June 1, 2021

**LETTER OF INTENT
CROWE SUBDIVISION FILING NO. 1
MINOR SUBDIVISION**

# CROWE SUBDIVISION FILING NO. 1

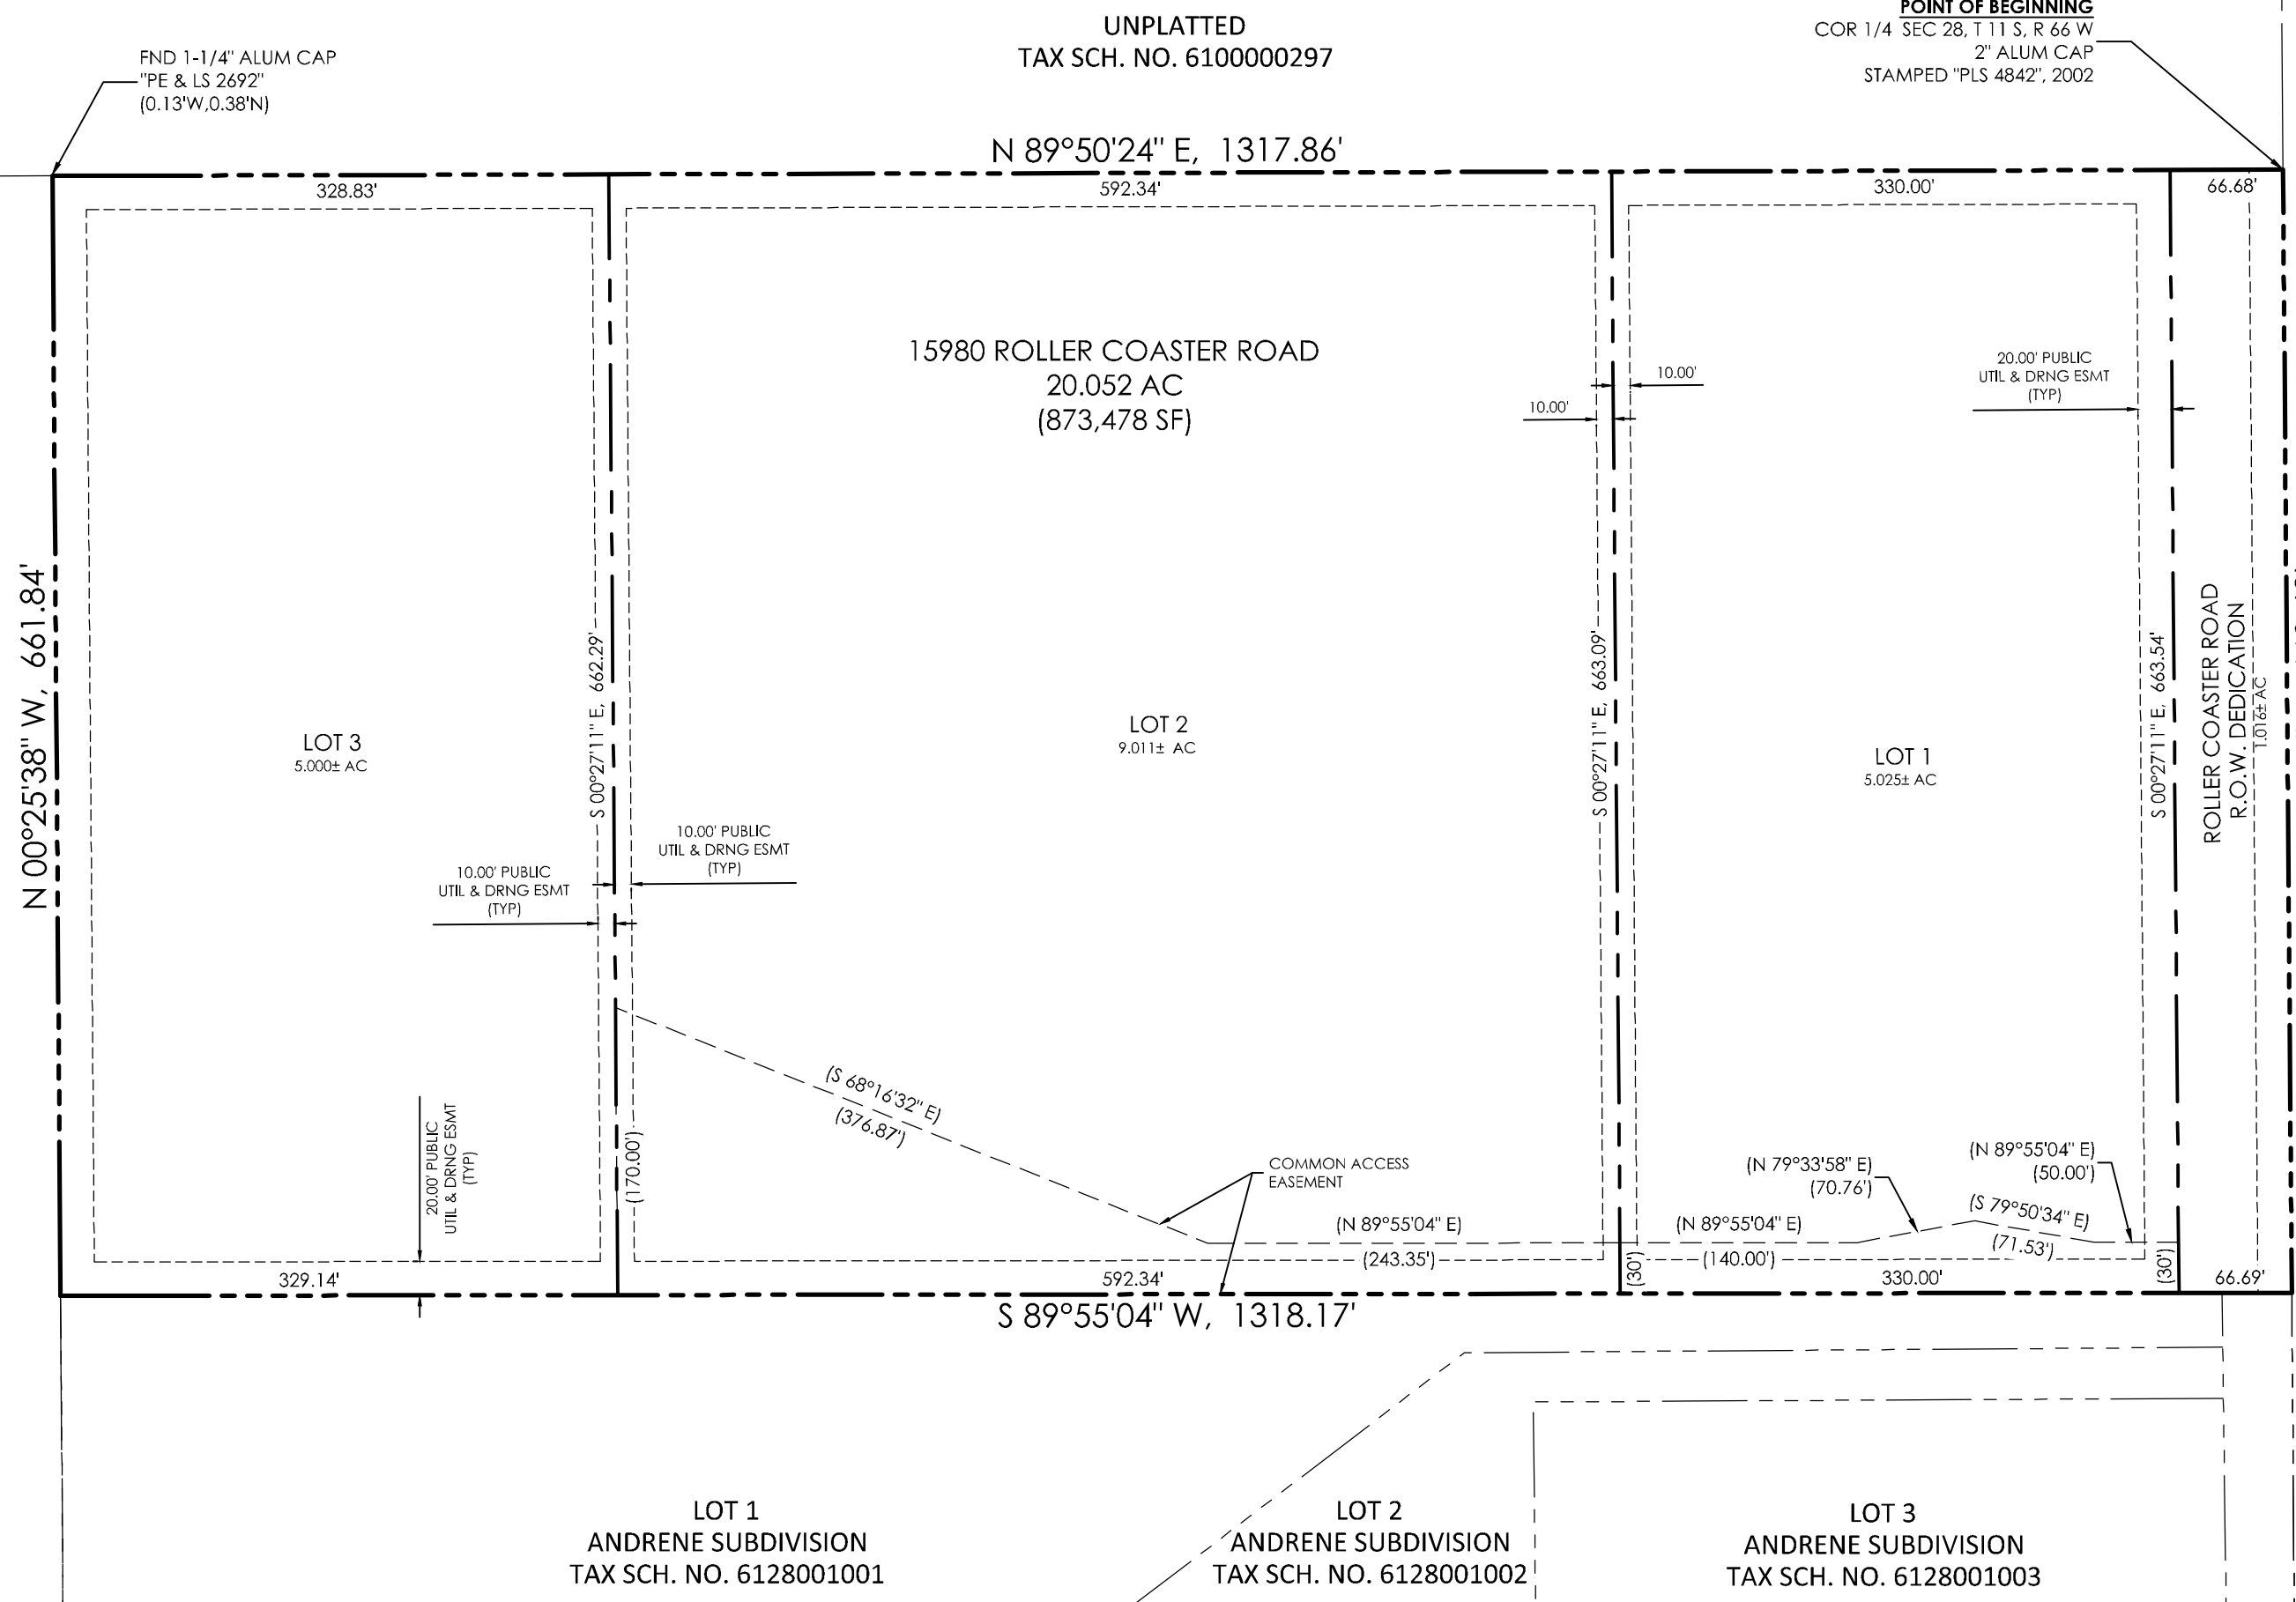
Only one access point will be allowed to Roller Coaster Road for all 3 lots. The plat shows a joint access easement along the south property line of the parcel. Please be sure to indicate that in the letter of intent.
